CITY OF PORTLAND

July 8, 1999

RE: 92 Farnham Street, 310-F-023, R-3 Zone

Proposed dwelling 92 Farnham St.

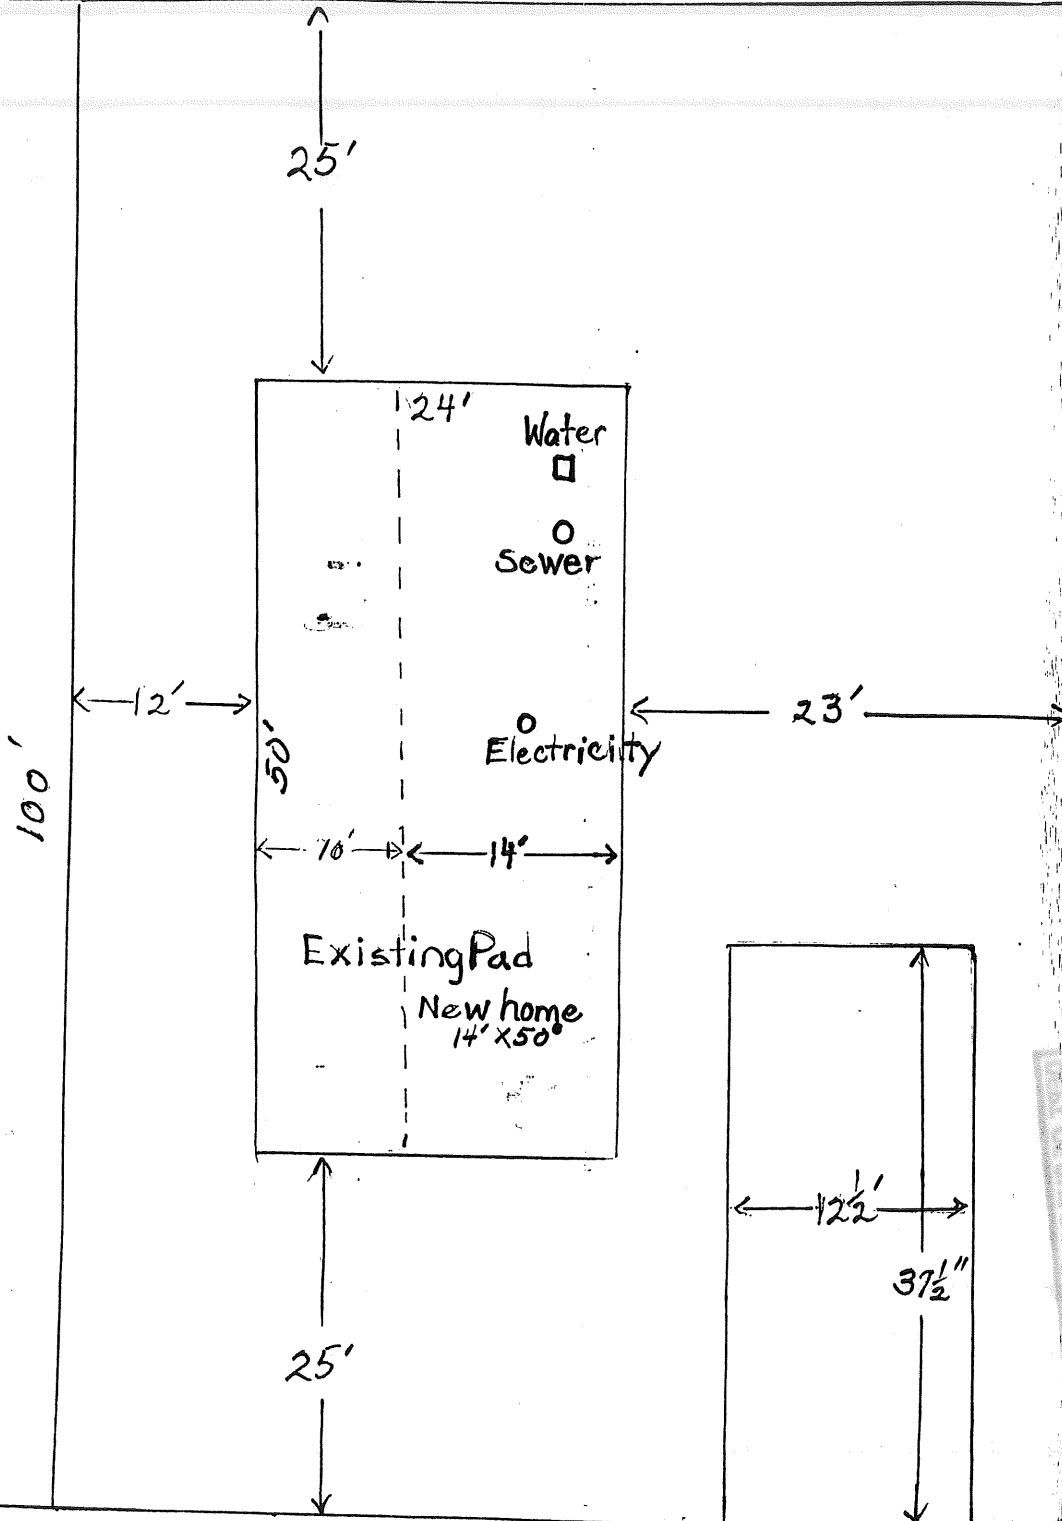
I am in receipt of your permit application to install a manufactured home at 92 Farnham Street. Your plans that you submitted are incomplete for a full review. Although, you show the placement of the structure on an angle, you are not showing where the existing pad is in relationship to the structure placement. I will need a revised plan showing where the pad is in relationship to the structure. We want to be sure the structure is securely placed.

I would also like verification from you that the setbacks that you show on your submitted plan are setbacks from your lot lines, and not from the street pavement line, or some other side or rear line. These should be from your actual lot lines. As you know, if and when this permit is issued, you shall be responsible to show the inspector exactly where those lot lines are placed so that accurate measurements can be made for the lot line setbacks.
